RE: Lorson Boulevard Bridge Design. El Paso County, Colorado (Kiowa Project No. 17001)

CDR-18-002 Lorson East, East Fork Jimmy Camp Creek Lorson Bridge Design- Final Submittal

## LORSON RANCH LORSON BOULEVARD BRIDGE GENERAL BRIDGE PLAN EL PASO COUNTY, COLORADO

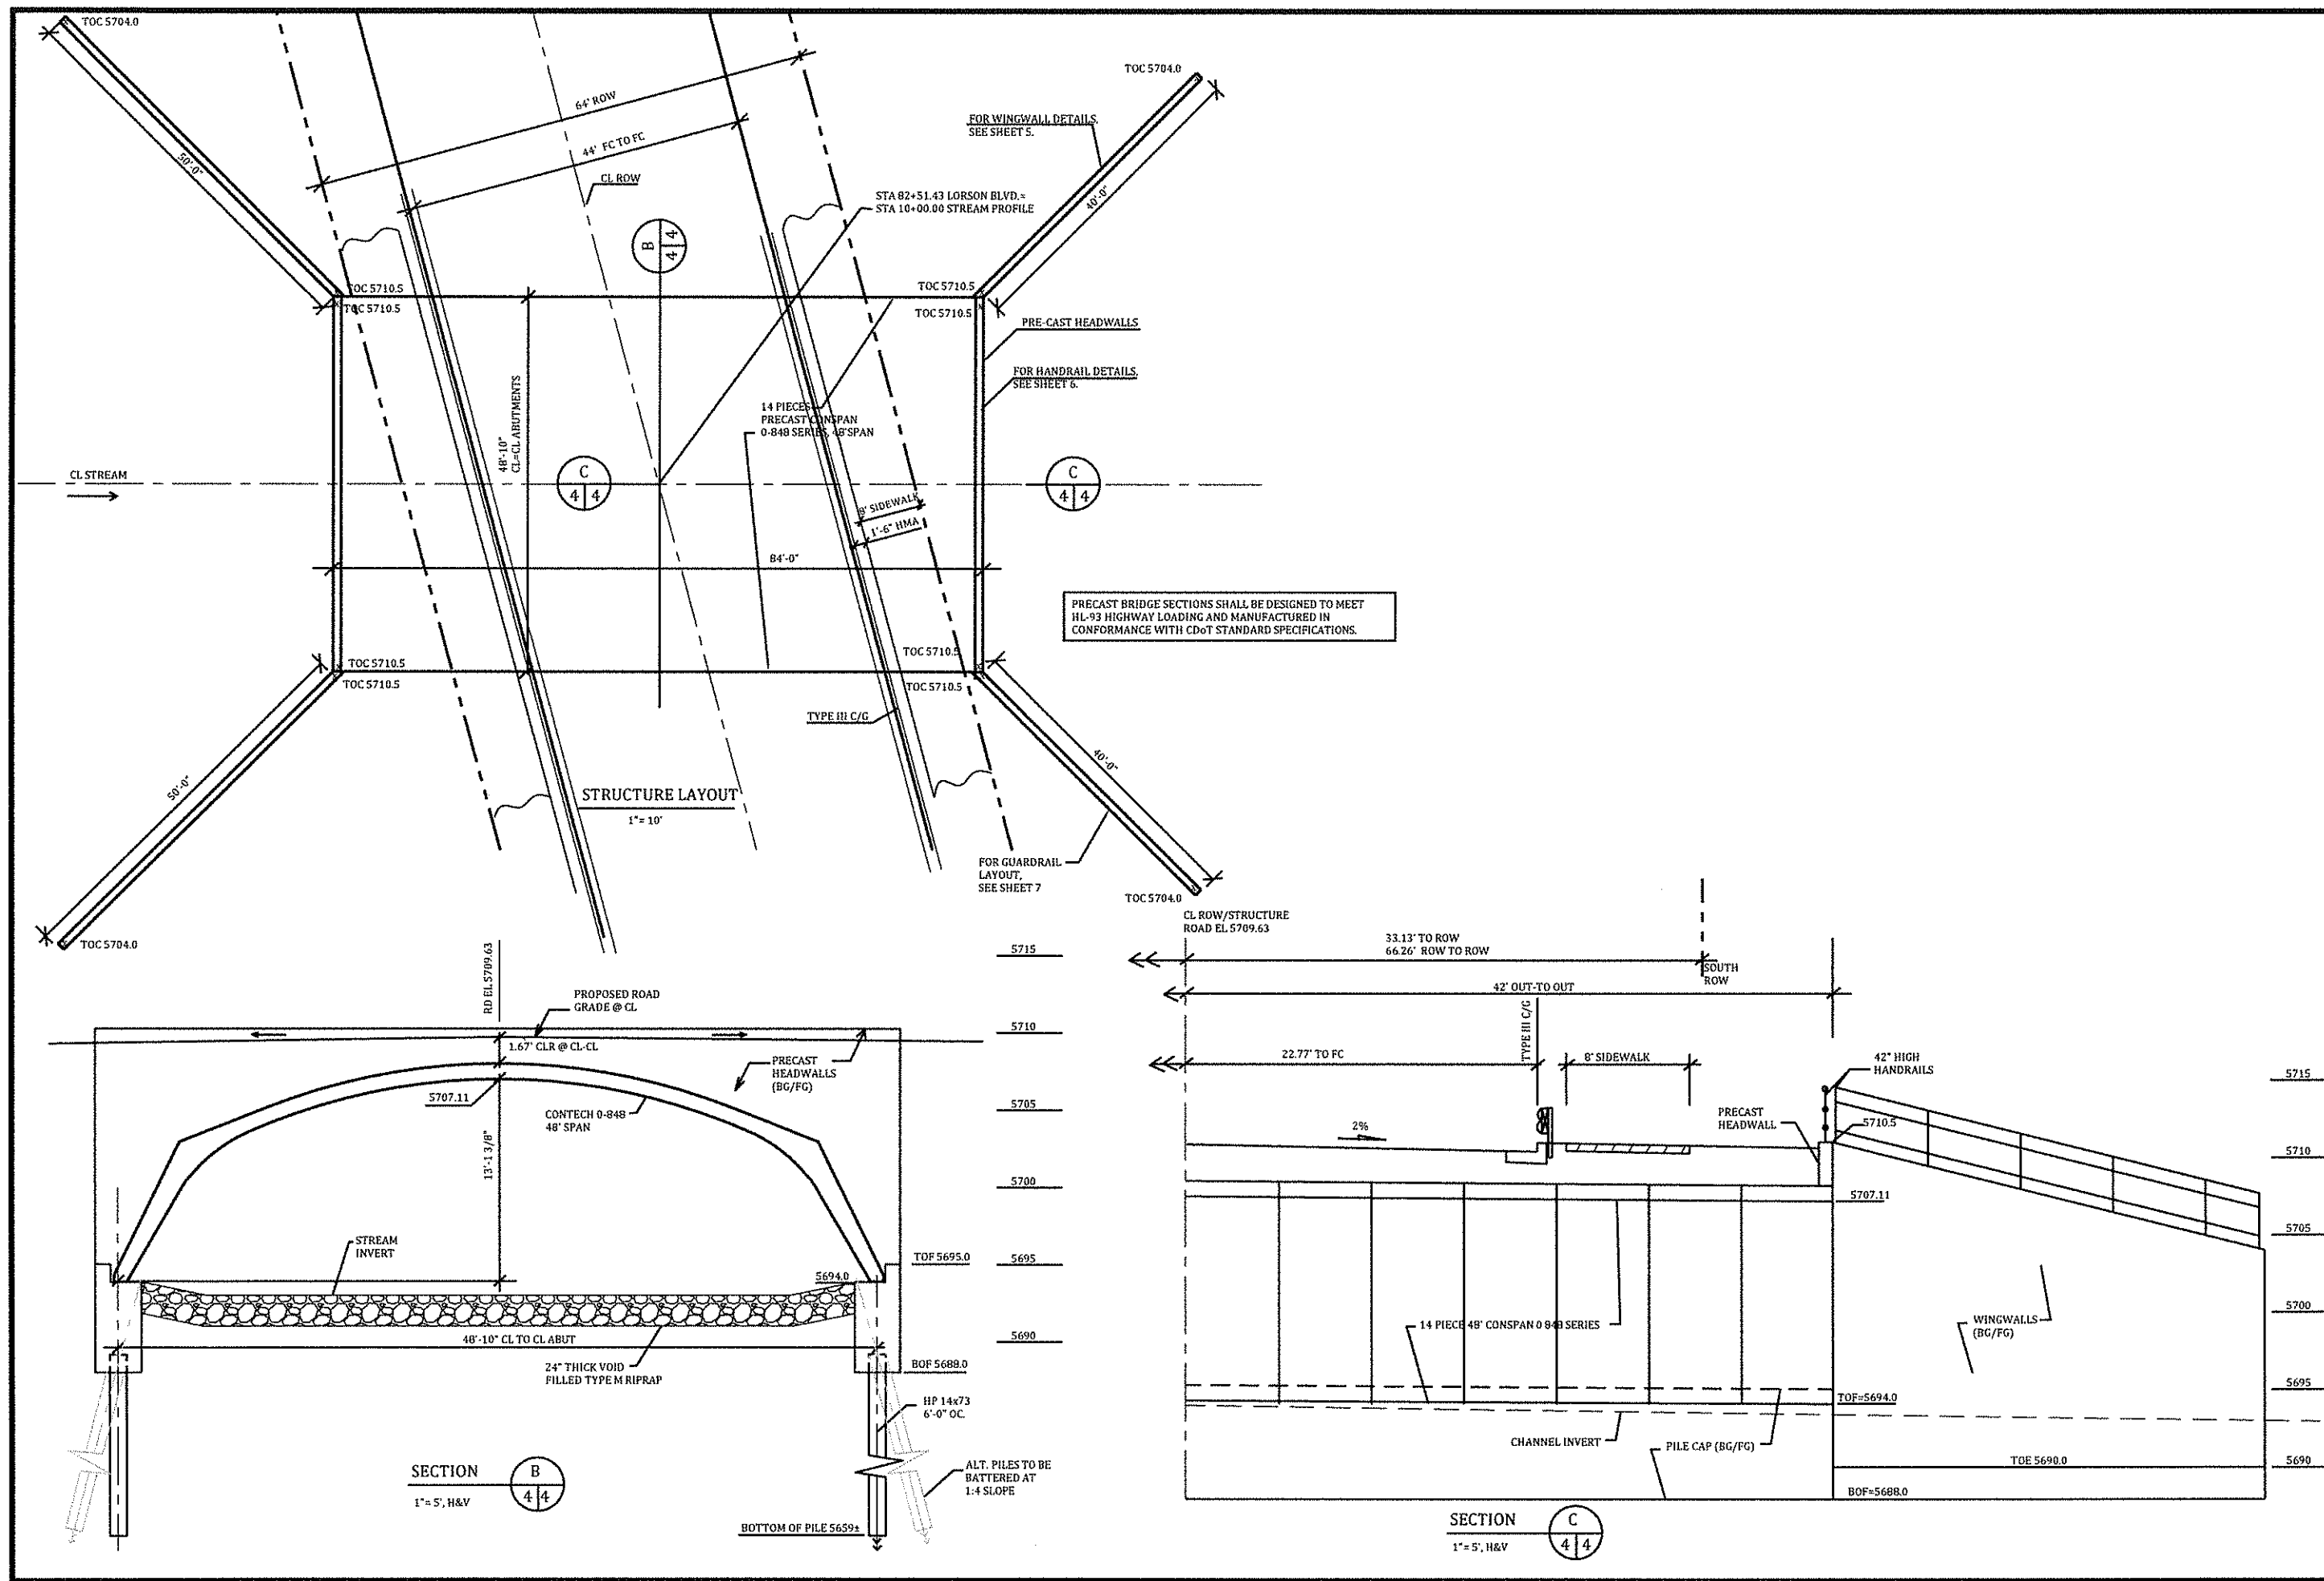
1. Show and label maintenance access roads. **Maintenance access road has been added to the plans.**
2. Based on a preliminary sketch of the plat area for Lorson Ranch East Filing No. 1, it appears that additional easements and/or ROW south of the plat area may be required. If so, revise the plat area (for ROW covering the bridge structure) and/or show and label any necessary easements on the plans. If applicable, provide easement documents when available. **Easements up and downstream of the right-of-way have been added to the plans. Legal exhibits and descriptions will be provided upon approval of the plans.**
3. Provide a note referencing CDOT Standard Specifications (2017) Section 502 regarding piles. **Note added to the plans.**
4. See redlines for additional comments and clarification. **Comments noted on the relined report have been addressed.**

**LORSON RANCH  
LORSON BOULEVARD BRIDGE  
GRADING PLAN & EROSION CONTROL PLAN**  
EL PASO COUNTY, COLORADO

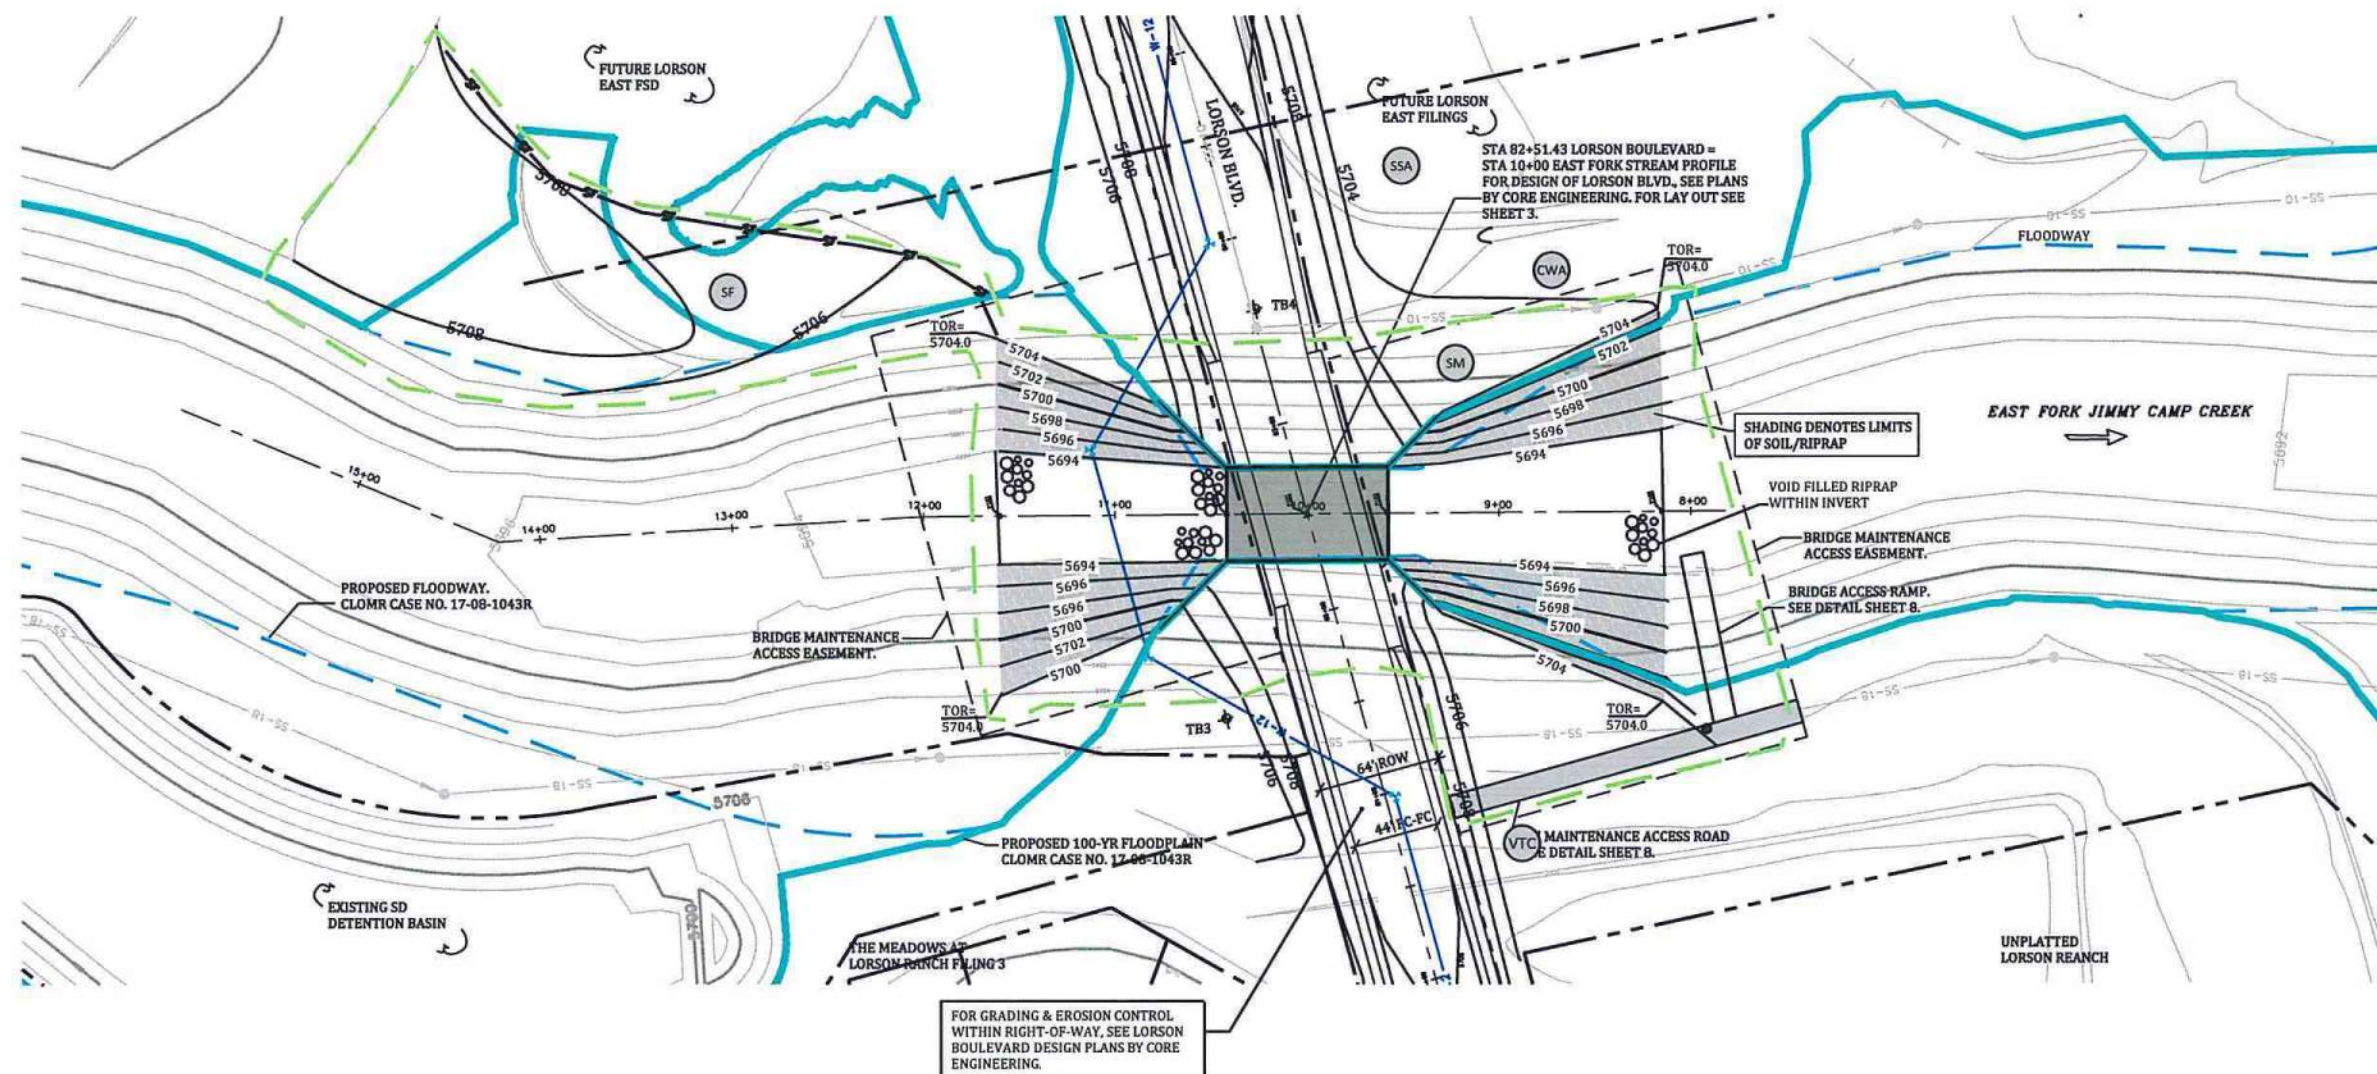
1. Include all linetypes/symbols in the legend. Show existing contours as dashed and proposed as solid linetypes. **Additional line types have been added to the legend on sheet 8 of the plans.**
2. Provide all applicable checklist items (attached). **Noted**
